**Re: Tulane Office Addition and Remodel, 201 Tulane Ave. SE, Certificate of Occupancy**

Re: Certification Submittal for Final Building Certificate of Occupancy for  
Tulane Office Addition & Remodel, [K-16 / D64]  
201 Tulane Ave. SE  
Architect's Stamp Dated 02/23/04

**Re: Tulane Office Addition & Remodel  
Traffic Circulation Layout (K-16/D64)  
Architect's Stamp Dated 5-30-03**

1 SITE PLAN
SCALE: 1"=10'-0"

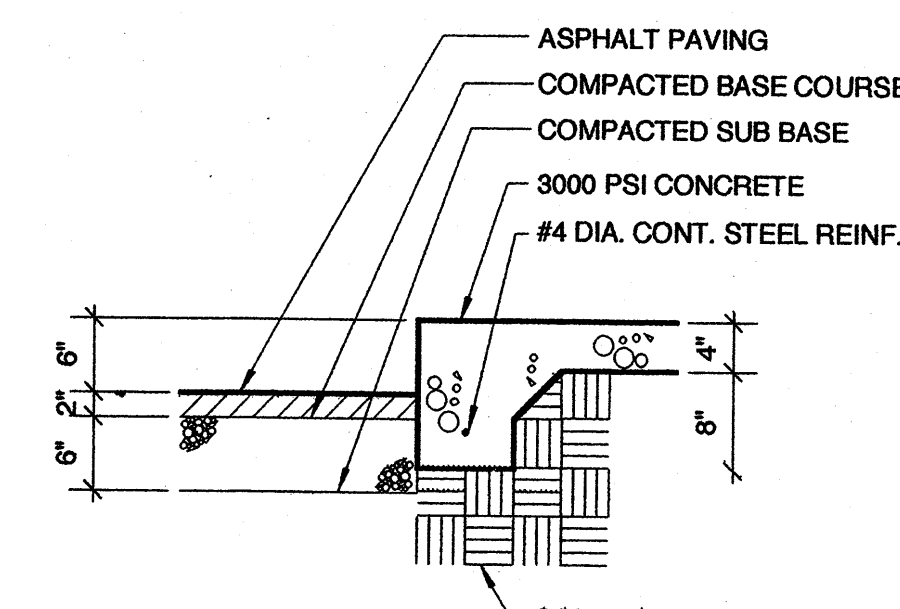
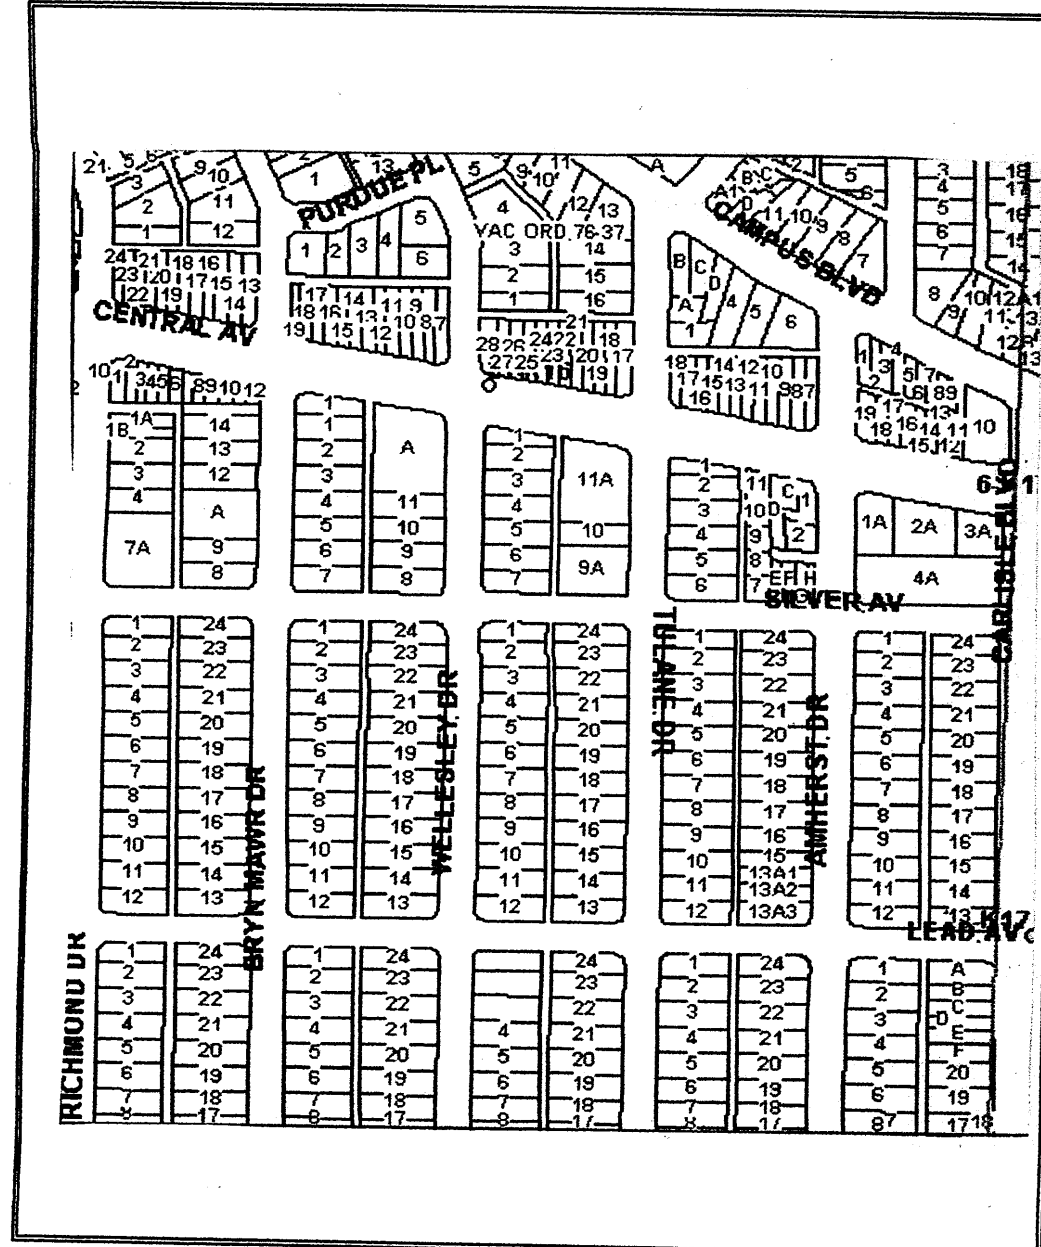
- Please show handicap accessibility for drive-pad.

The TCL / Letter of Certification submitted on March 1, 2004 is not sufficient for acceptance by this office for final Certificate of Occupancy (C.O.). The following items will need to be addressed:

- A final TCL was not submitted for approval and will need to be submitted for final review (in accordance with Traffic Circulation Layout letter dated July 8, 2003).
- A work order will be needed for alley paving (in accordance with Grading and Drainage letter dated July 8, 2003).

The TCL (or DRB Site Plan) submitted for Final C.O. needs to be the exact copy of the approved TCL in the plan set approved for building permit. This will be the latest edition, which may have redlined comments, initialled and dated by the designer-of-record.

I am writing this letter to inform you that I have inspected the subject property on February 23, 2004 and found that the site was built in substantial compliance with the approved Traffic Circulation Layout (TCL). We are submitting an "As Built" Site Plan showing the changes that have occurred by change order during the course of construction for your review and approval. We are requesting final approval for C.O. at this time.
